**Subject:** SE-25-00019 Schmaus - Notice of Application

**RE: SEPA 202505198; SE-25-00019**

**TO:** All Staff  
**FROM:** Public Works Plan Review Team  
**DATE:** January 5, 2026  
**SUBJECT:** SE-25-00019 Schmaus

RE: SE-25-00019, Schmaus  
SR 970 milepost 4.99 – milepost 5.12 right.

SCHMAUS RESIDENCE
 SCHMAUS HAUS, LLC
 SITE PLAN

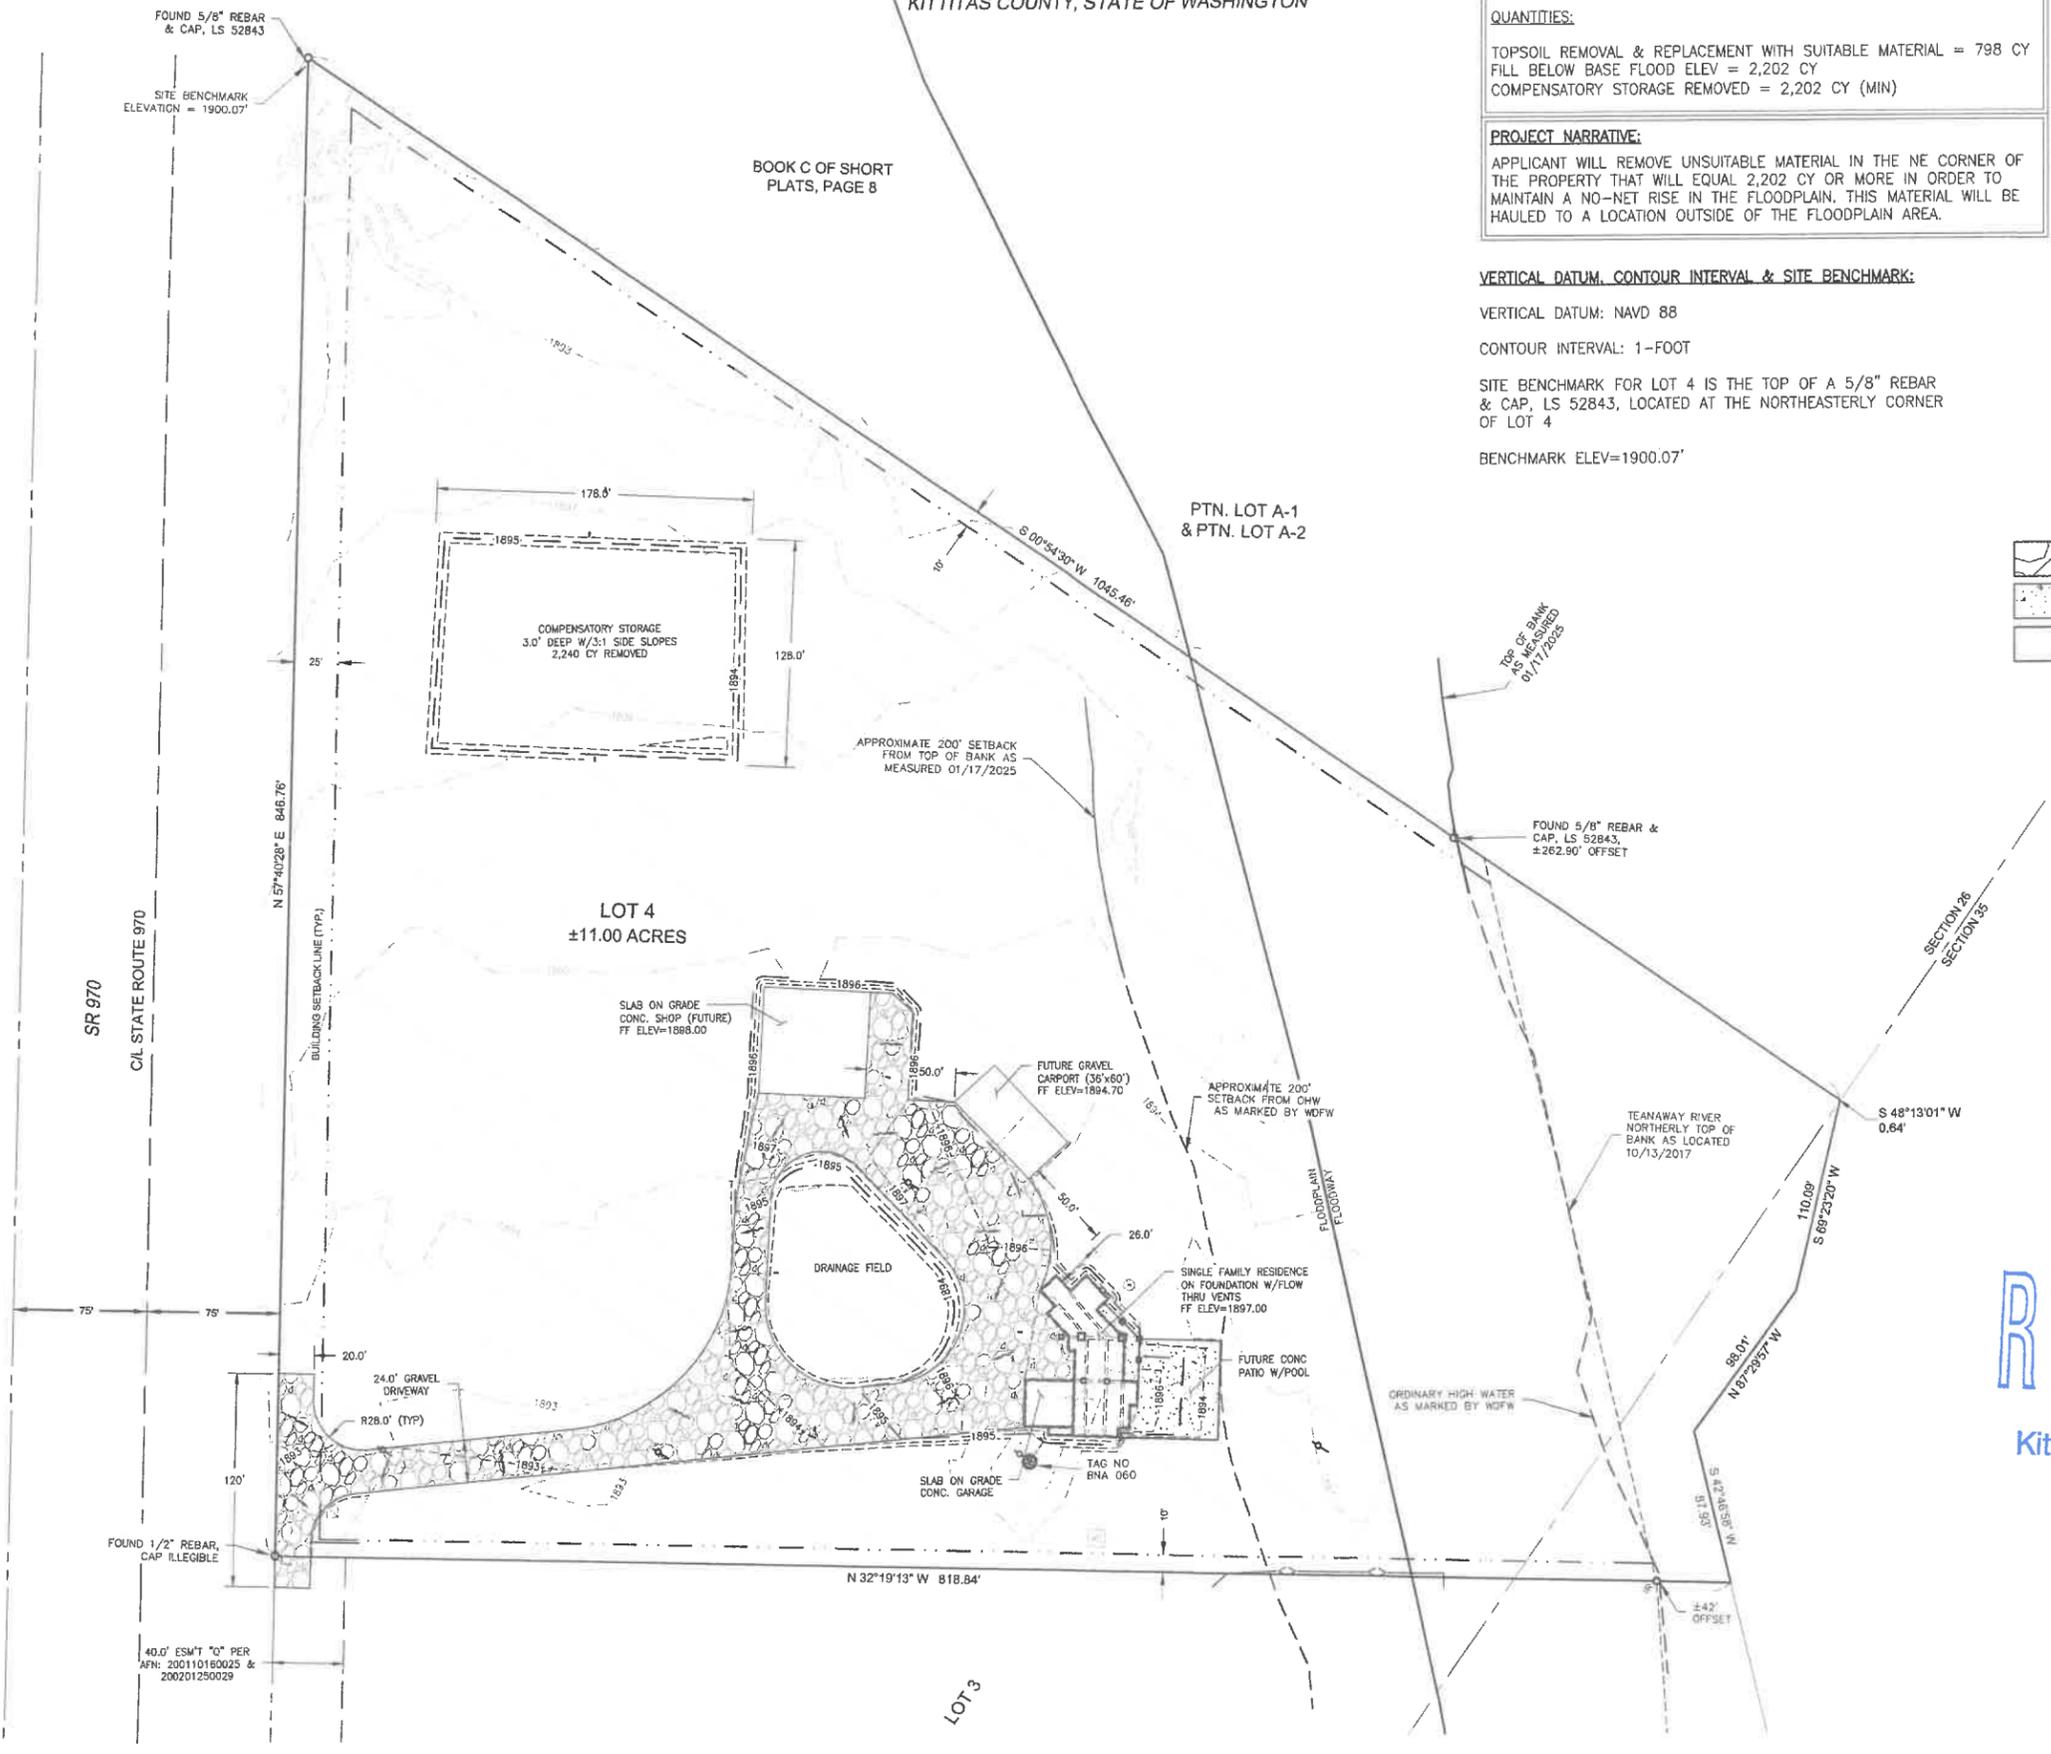
<b>SURVEY</b>	The proposed development includes installation of a gravel driveway over an existing property corner. If this corner is disturbed or destroyed by these activities, it shall be replaced by a land surveyor licensed to practice in Washington State. (JT)
<b>TRANSPORTATION CONCURRENCY</b>	No transportation concurrency management application required for this project as described. (KAH)

<b>FLOOD</b>	The proposed development requires a floodplain development permit and must meet KCC 14.08 requirements. Public Works has received a floodplain development application for the project (FD-25-00021) that is under review. The parcel contains FEMA designated floodway. Per the submitted site plan, the proposed development is located outside the floodway. Please be advised that the floodway is highly restricted and any development within the floodway boundary must be permitted through a floodplain development permit and must demonstrate no rise of 100-year flood elevations before being permitted. No new or substantially improved residences are allowed within the Floodway. (SC)
<b>WATER MITIGATION/ METERING</b>	No comments. (SC)
<b>AIRPORT</b>	No Comments. (RC)
